Consultation Response from KC Landscape	
Application No:	2023/91280
Proposed Development:	Extension to previous Bromley Farm Quarry for extraction of clay, shale and incidental coal
Location:	Bromley Farm Quarry, Barnsley Road, Upper Cumberworth, Huddersfield, HD8 8PD
Applicant/Agent:	Silkstone Environmental Ltd
Planning Officer	Farzana Tabasum
Date Responded:	17/07/23
Responding Officer:	AR
Responding Ref:	MM57

Landscape Context and Concept, Landscape Design

REV	DATE	DESCRIPTION
PROJECT		
BROMLEY FARM QUARRY, UPPER CUMBERWORTH		
TITLE		
ACCESS PROPOSALS		
SCALE		
1:250 @ A1		
DRAWING		
2074-101		
DATE		
12.04.2022		
DRAWN	CHECKED	ALTERED
CH	AH	-

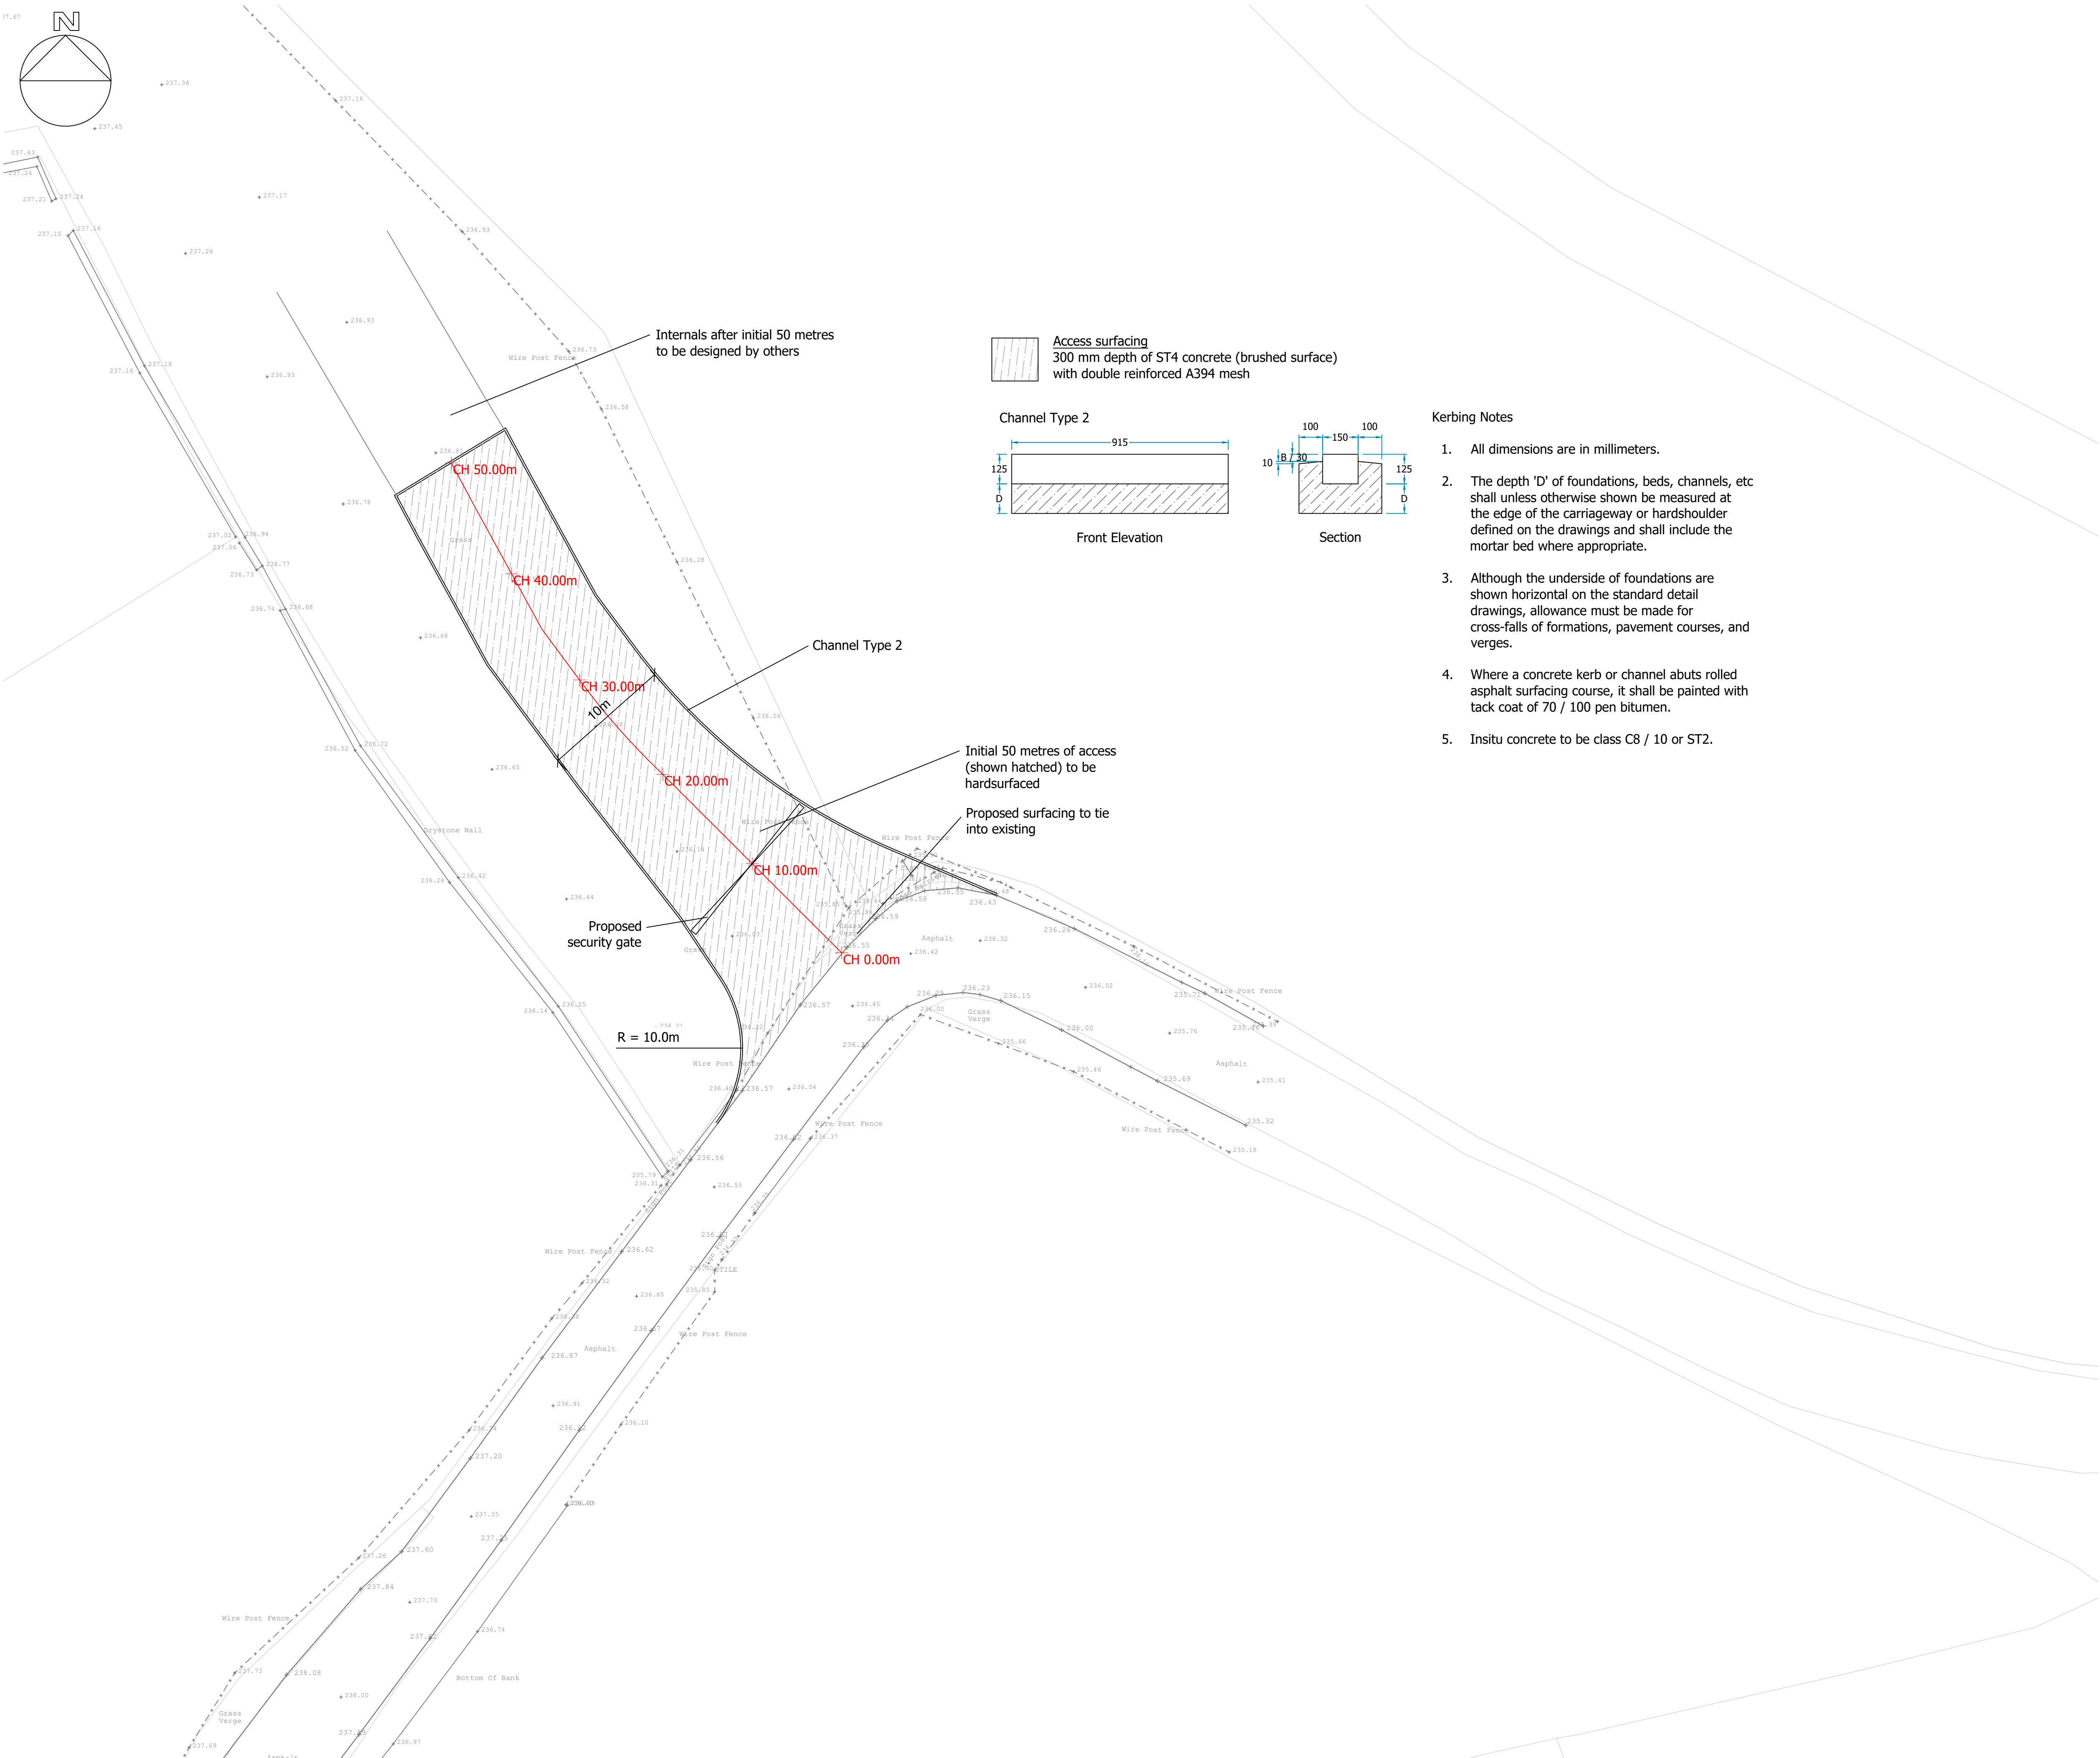
particularly the traffic associated with the quarrying operations will be visible from the adjacent PROW and occupiers of the properties south west of the proposed access. It is acknowledged, the case officer discussed this matter with the applicant during a recent site visit and applicant is willing to provide bunds/tree planting along this stretch to tie in with the existing bund and trees to the north west near Cumberworth Lane. This should be conditioned to be provided after top and sub soil stripping commences and before any mineral extraction takes place.

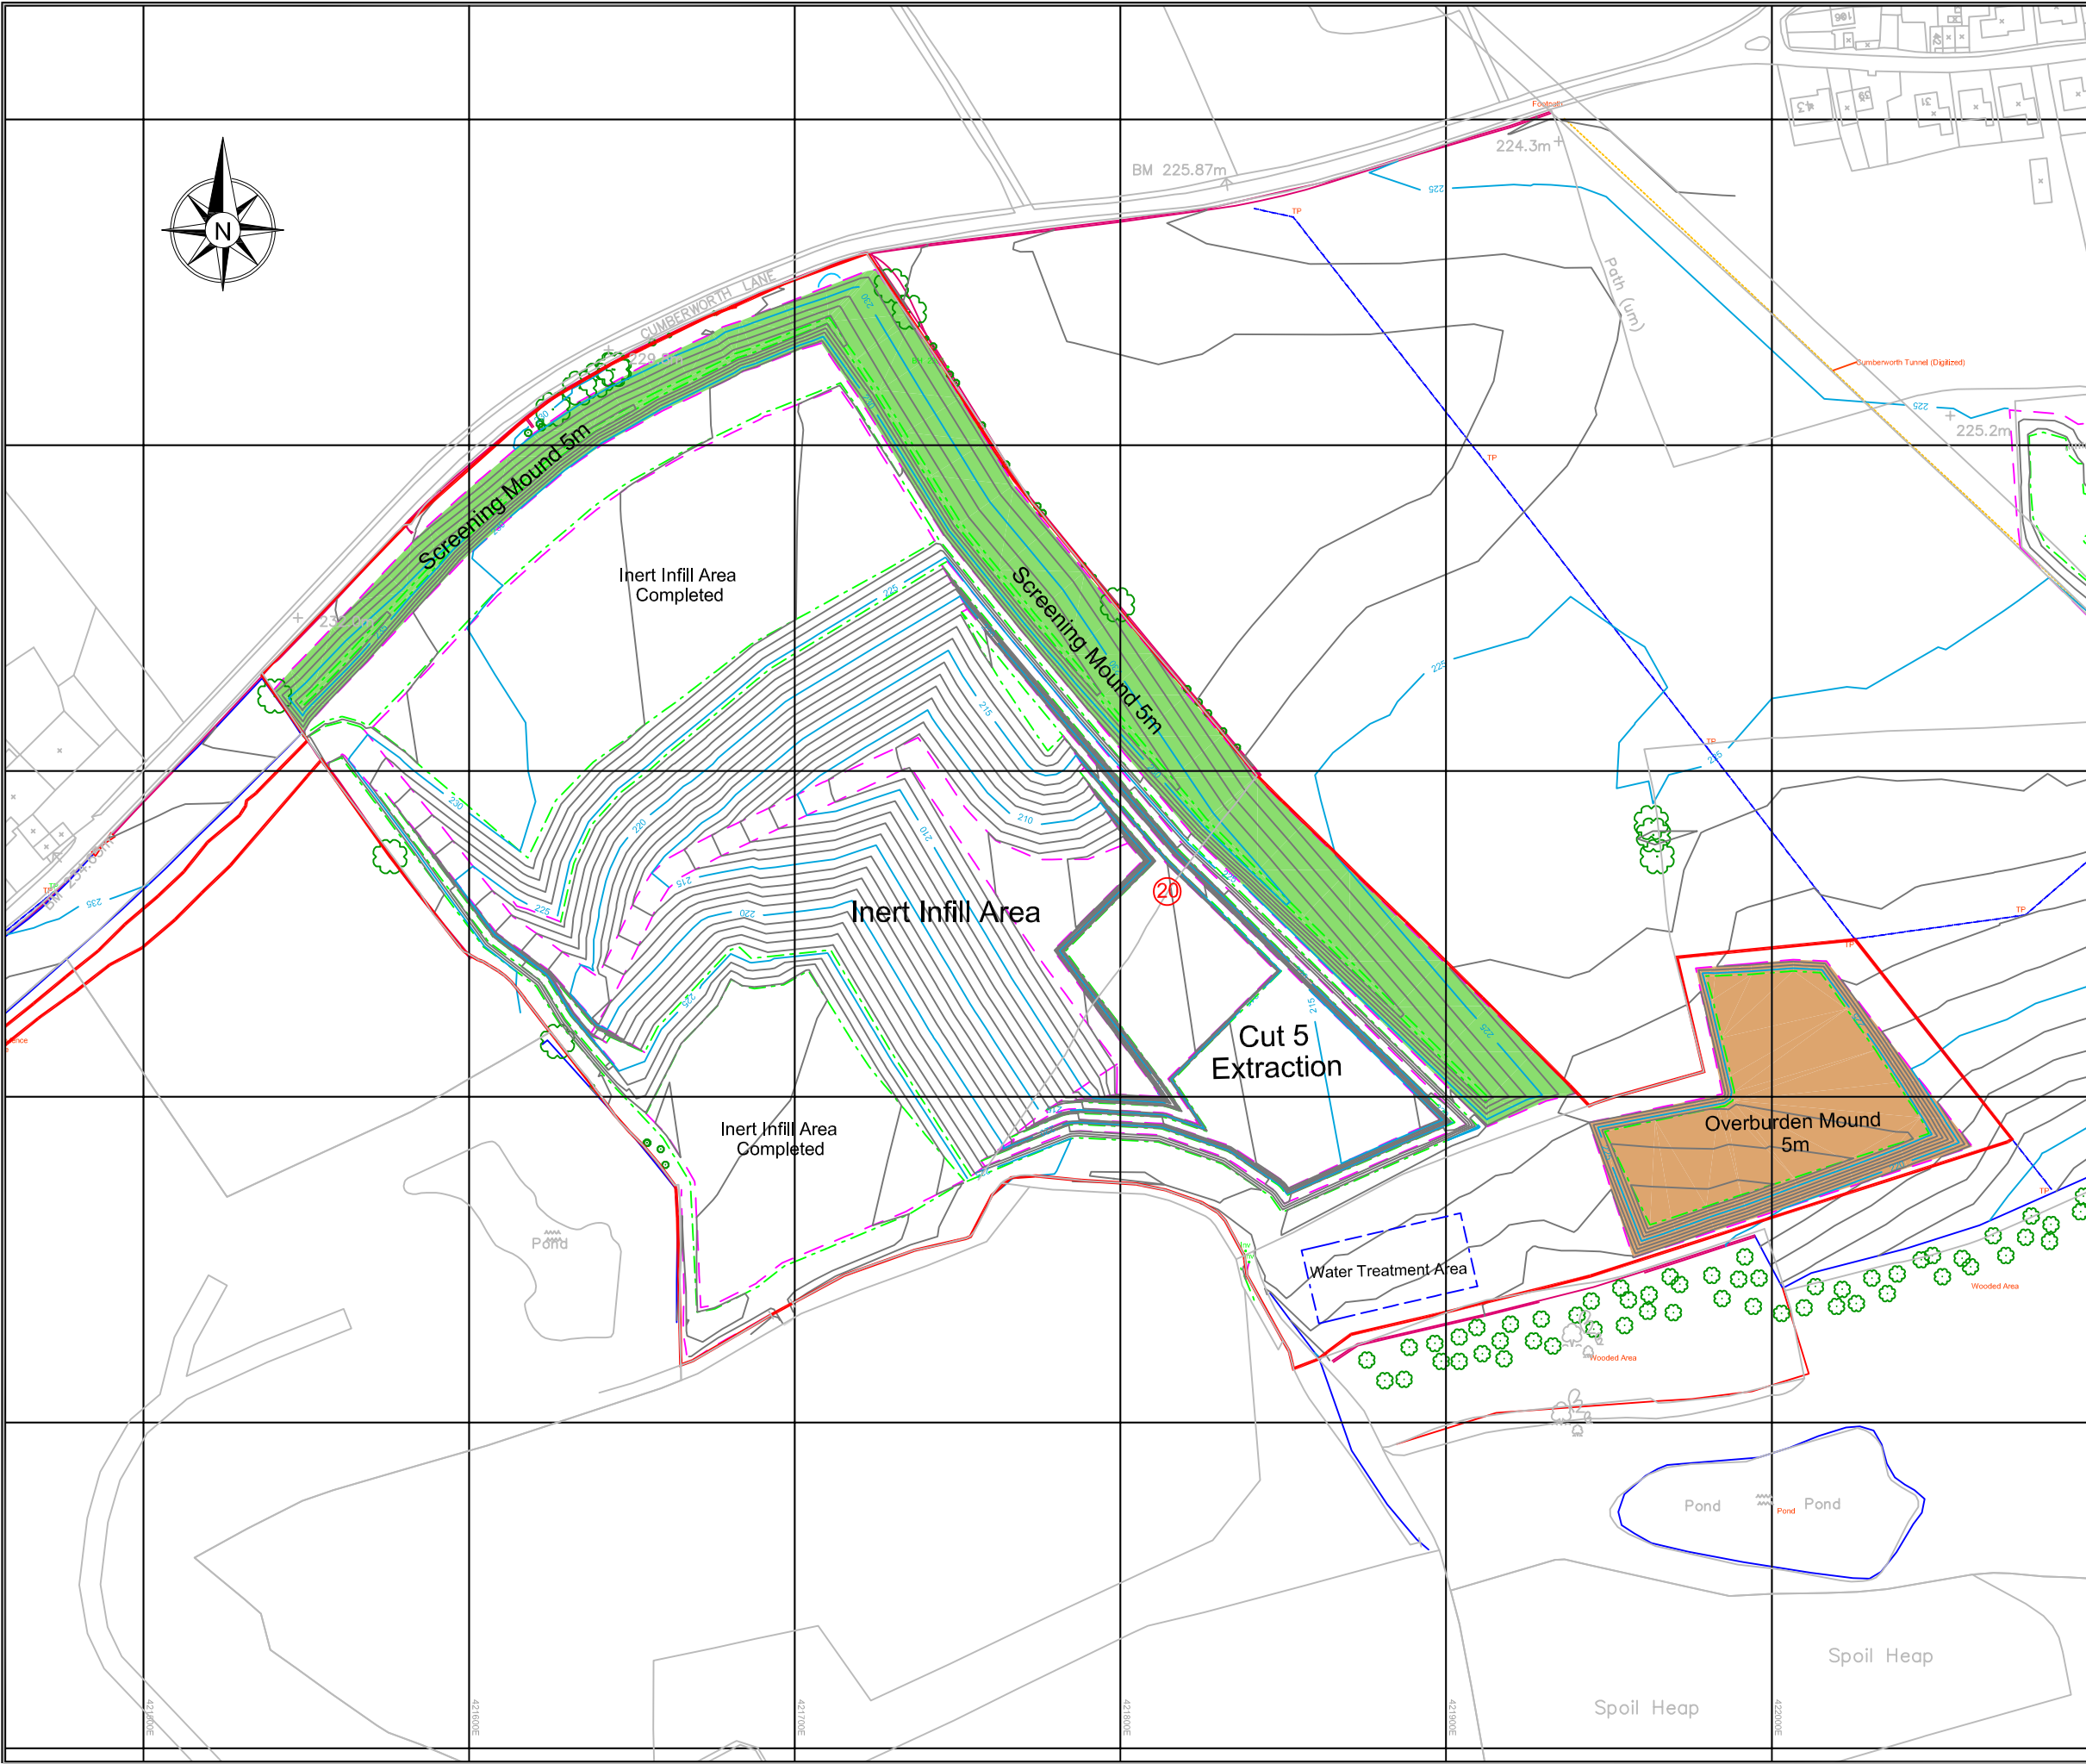
Landscape – It would be prudent to seek reassurance that the identified habitat network will be afforded suitable protection during the proposed 25year period of operations. This should be protected during works and evidence provided through the submission of standoff details required from the edge of this wildlife habitat network to the proposed cuts and overburden storage areas, prior to determination of the application.

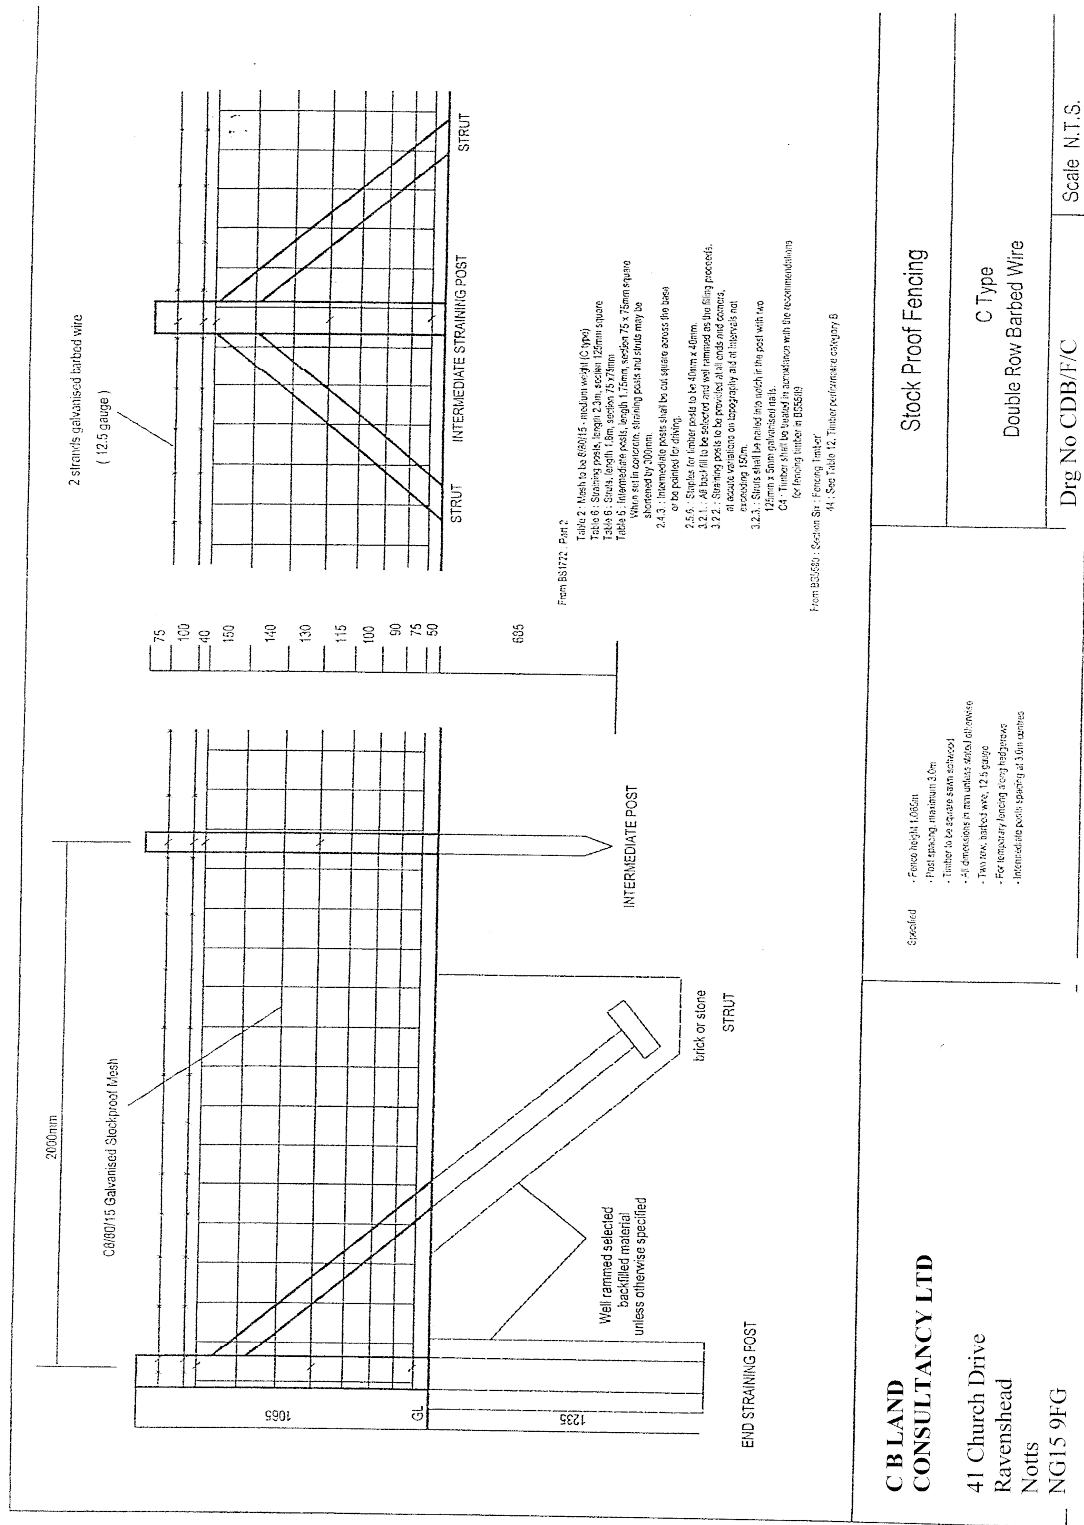
3. The restoration planting scheme is a sympathetic proposal and suitable for the setting. Boundary of the proposal comes up against identified habitat network it is not indicated as being removed and the proposed restoration plan will further enhance this existing habitat. Proposals include native species, light woodland tree planting, shrub planting, species rich grassland and replacement of the agricultural grassland. Aftercare report has included details on how the topsoil's will be stripped, managed and re-laid to avoid over compaction. The quantities of topsoil stripped will be measured and recorded. Depths will then be managed when reinstated ensuring even distribution. A five year maintenance plan has been included in the report and covers replacement of losses in the first three years, this is satisfactory.
